Conservation Officers response

LU/246/24/PL

Land at Toddington Lane Littlehampton BN17 7PN

Demolition of existing structures and development of land to create 10 No. residential dwellings, landscaping, access, car parking and cycle parking. This application may affect the setting of listed buildings, is in CIL zone 2 and is CIL liable as new dwellings.

Drawing title
Semi-Detached
Plots 1 - 2
Plans & Elevations

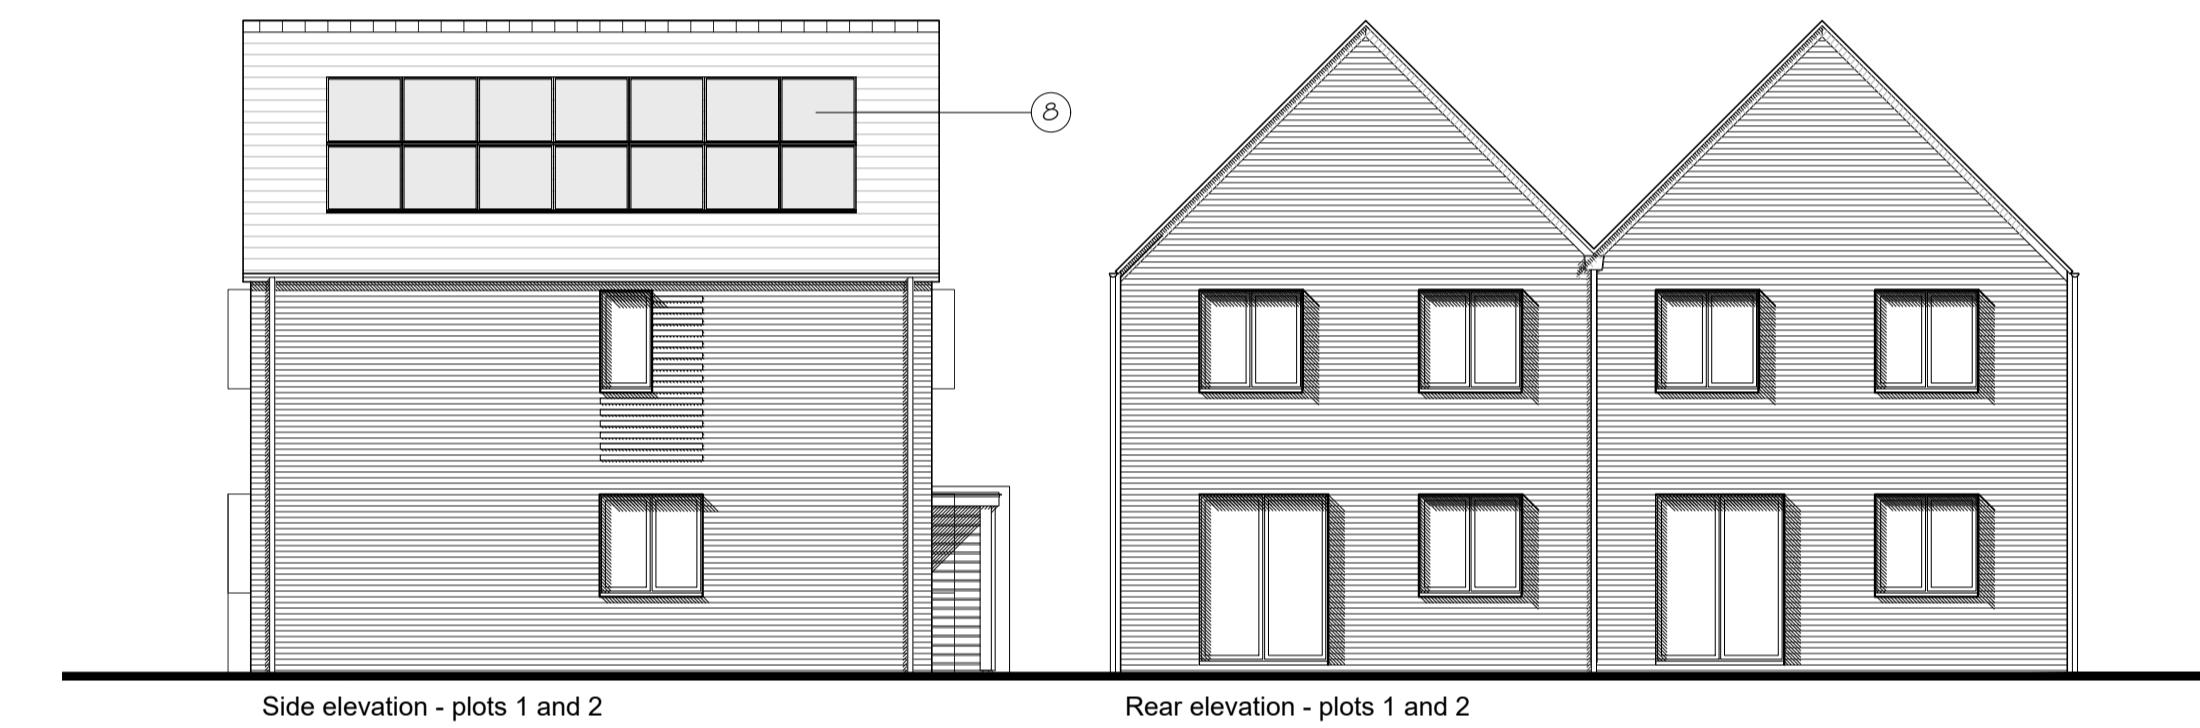
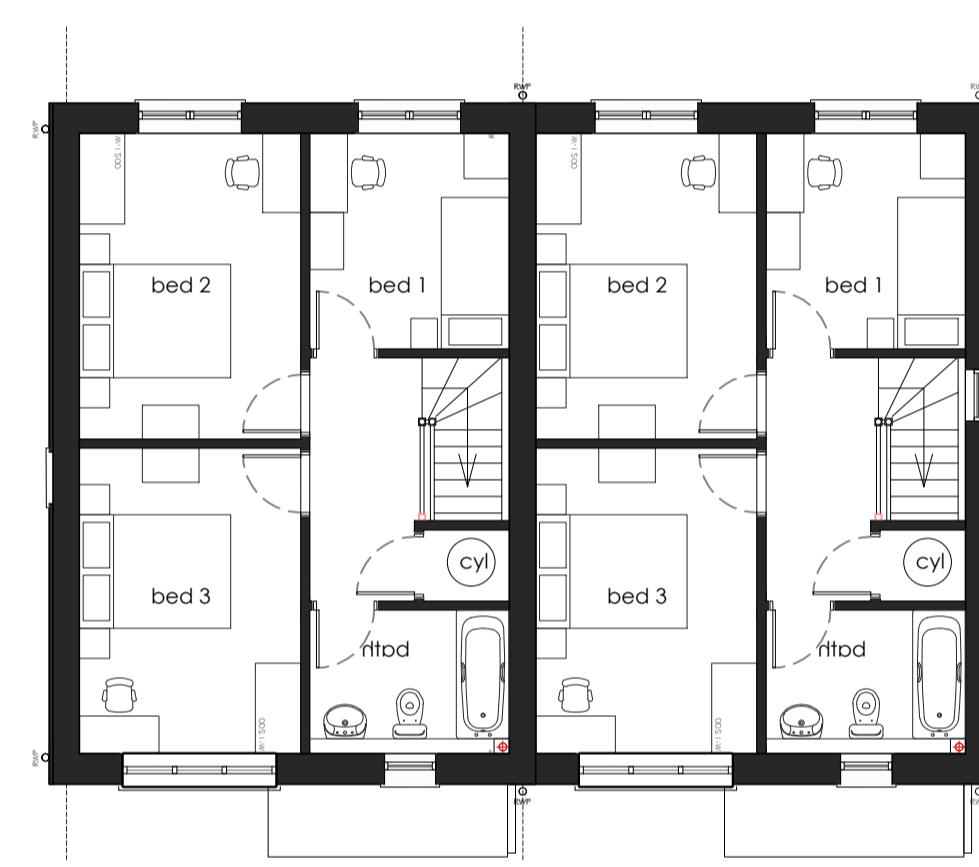
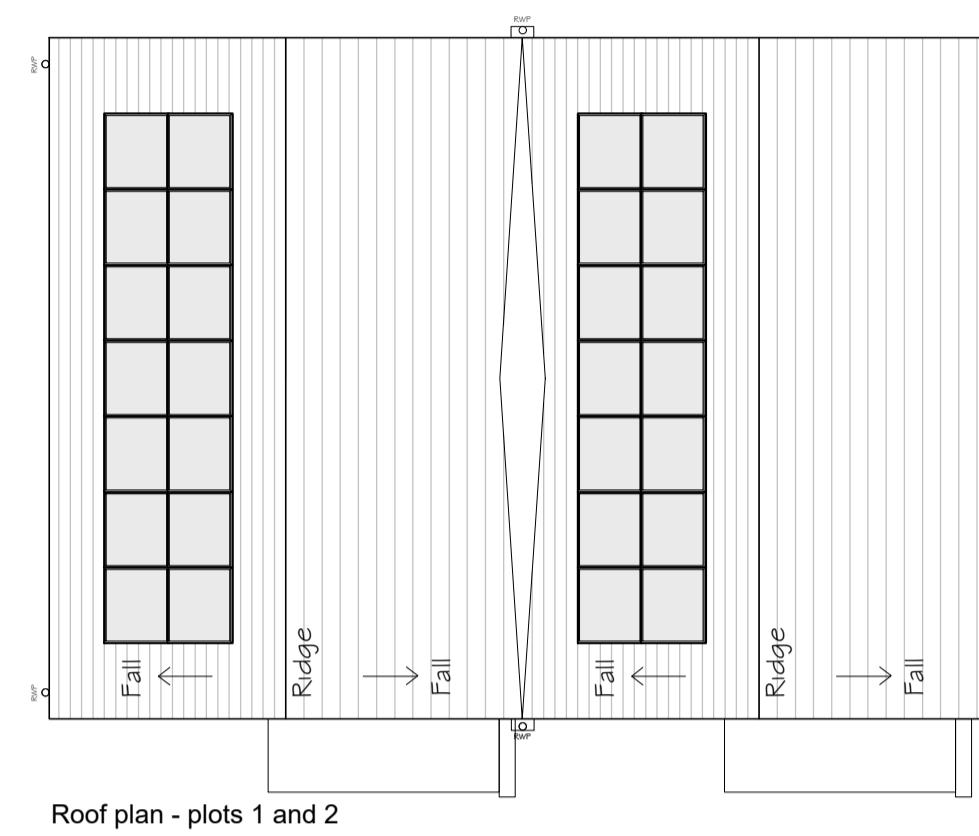
The houses are a modern design which we are informed responds to the local surroundings and landscape setting and incorporates local building characteristics. The concept of a modern design would seem to be logical as it is not always best to create a pastiche of a traditional property, especially when so close to positive listed buildings which are reflective of the local vernacular. This way, the dwellings can easily be read as new development. However, my only concern relates to the colour of the brick chosen which does not fully reflect the vernacular.
